**From:** [diane sumner](#)  
**To:** [Rachael Stevie \(CD\)](#)  
**Subject:** Response to Notice of Application RU 22-00002 East Peak Reasonable Use Variance  
**Date:** Friday, April 22, 2022 9:54:48 AM

Understand that this Notice of Application is merely a formality. The reasonable use exception request is asking to revert the setbacks to what was in place prior to Feb 2022 when new setback requirements were approved.

DEVELOPMENT, STORMWATER AND
PARKING PLAN - PARCEL B

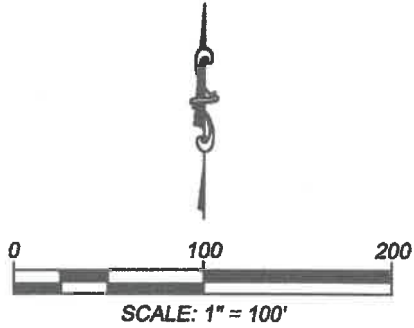
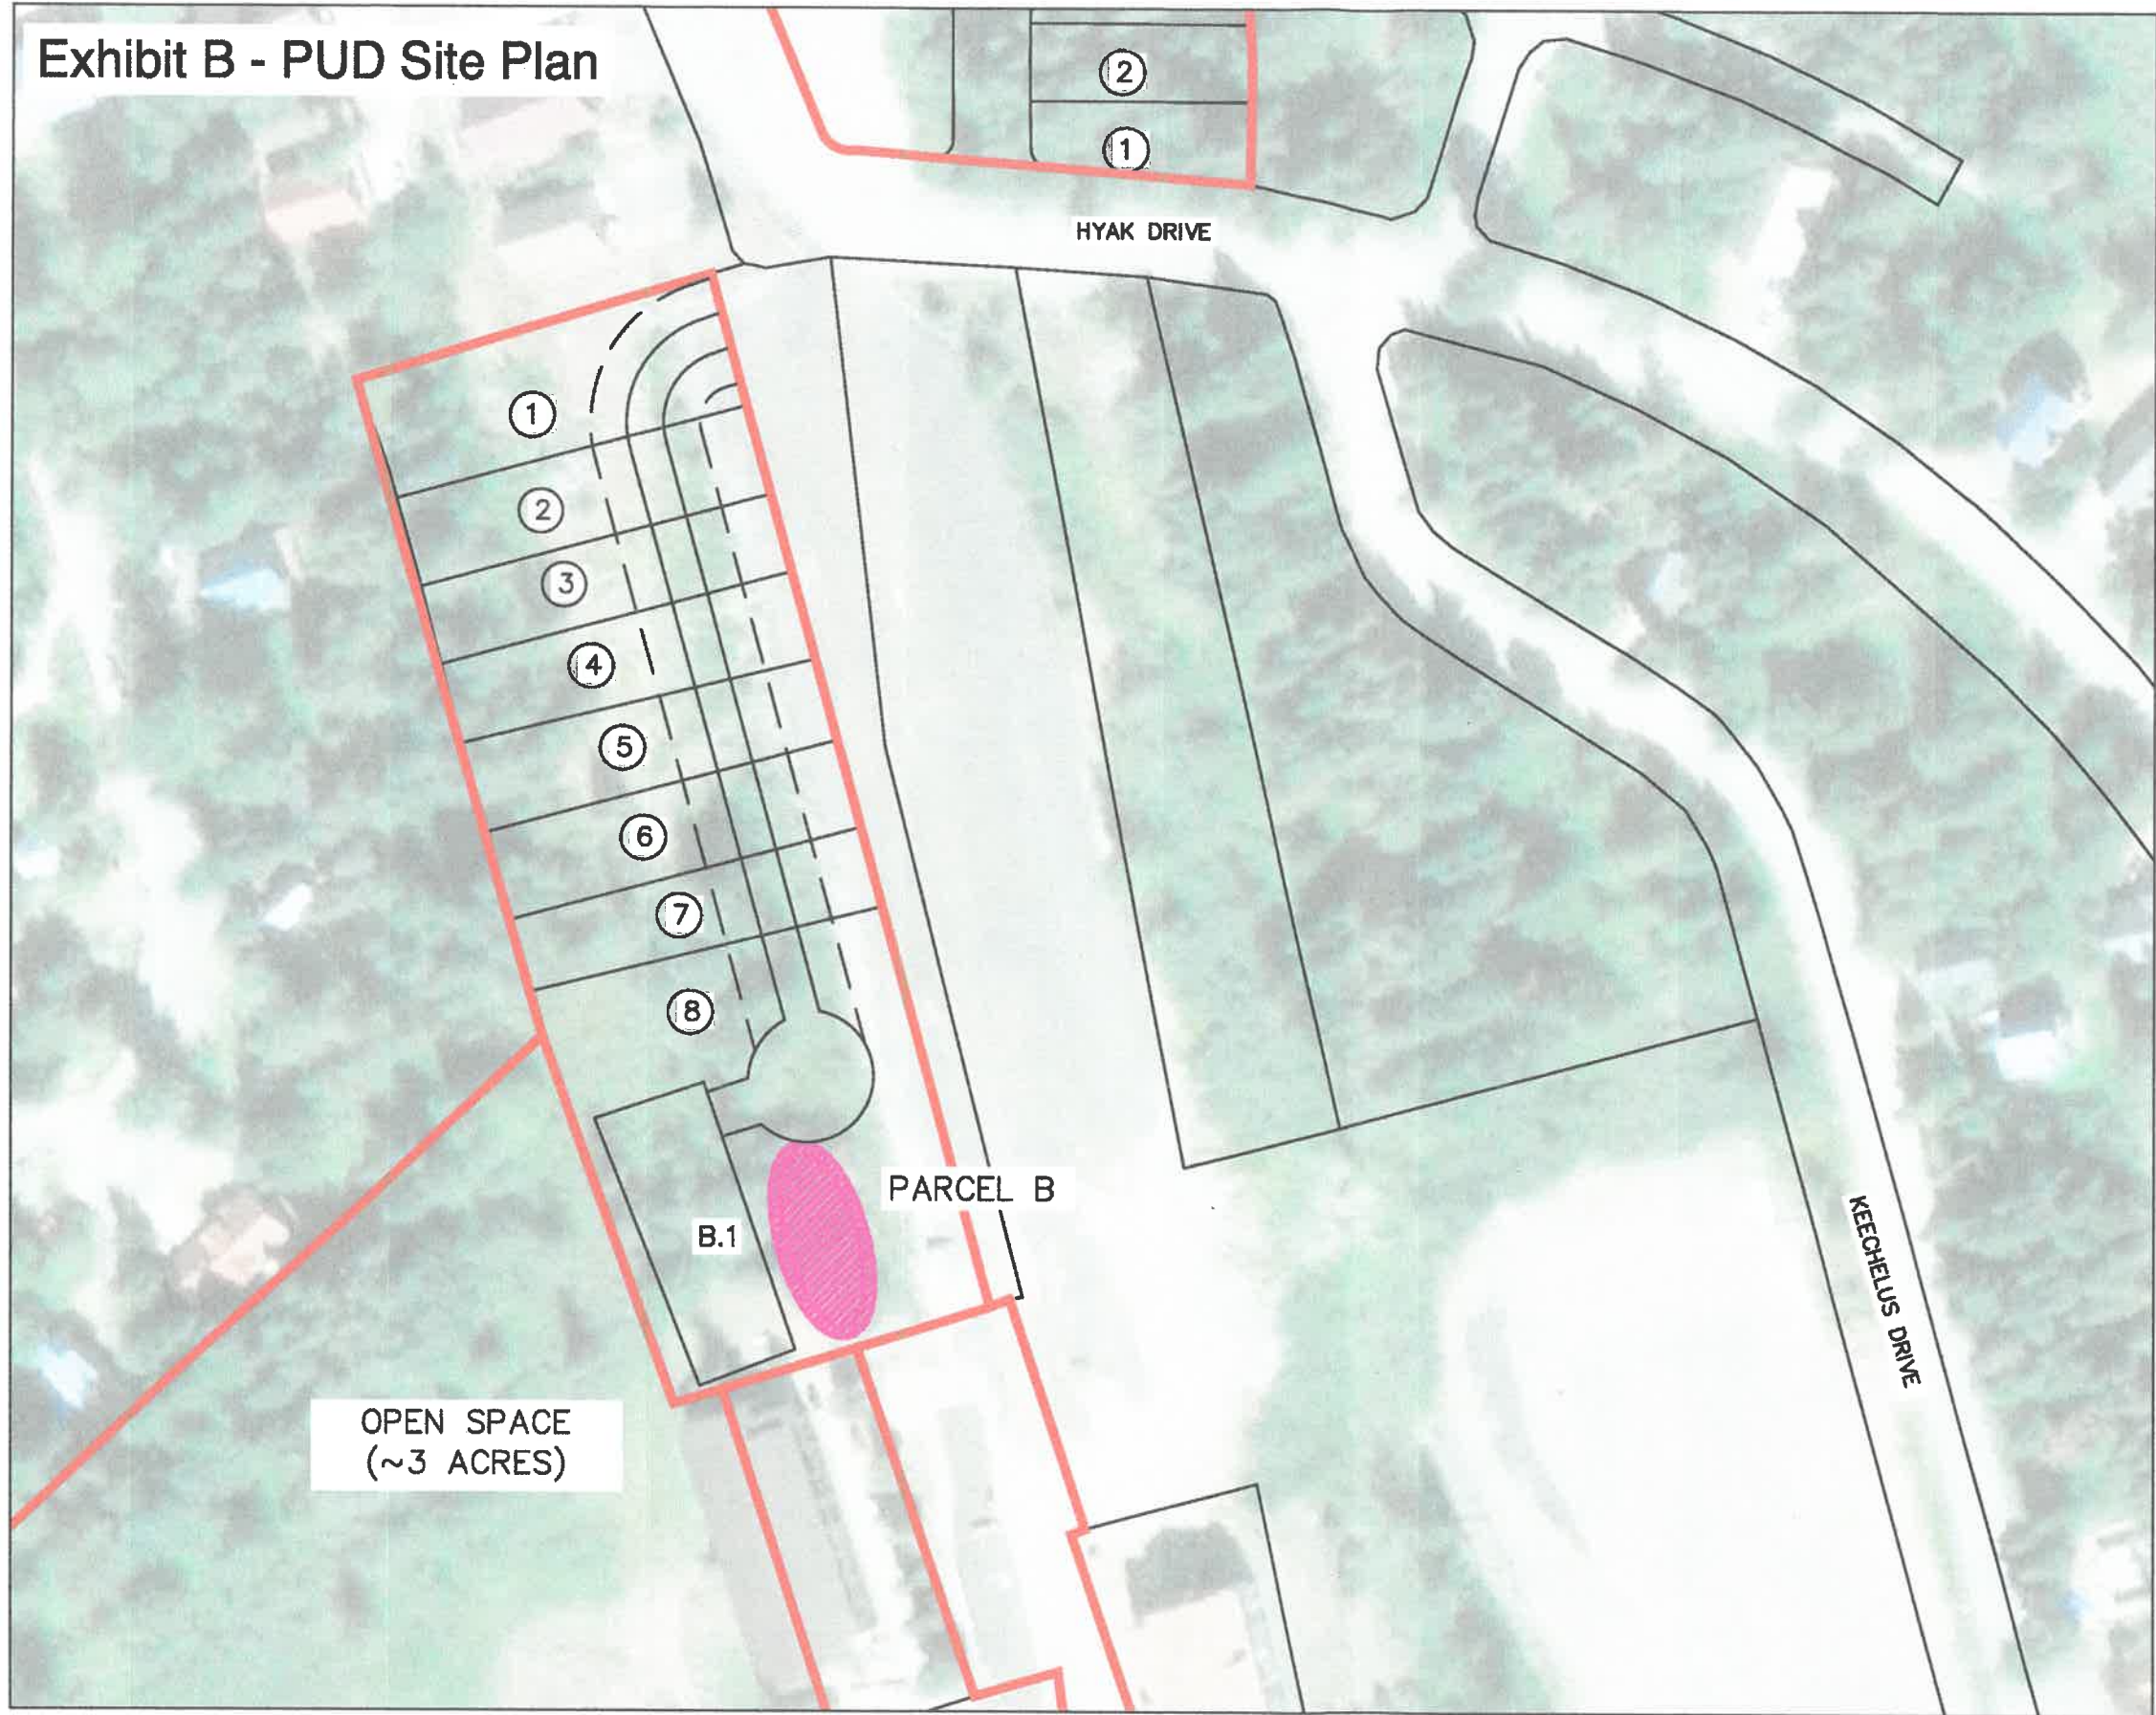
With that said, I do want to share some concerns specifically related to storm water run off. I would like to know where the storm water will be discharged or stored in this new development.

In lower Hyak, we have significant flooding issues that occur yearly. If there is not proper piping or storage (for example water vault under parking) designed into this development, I would like the county to address.
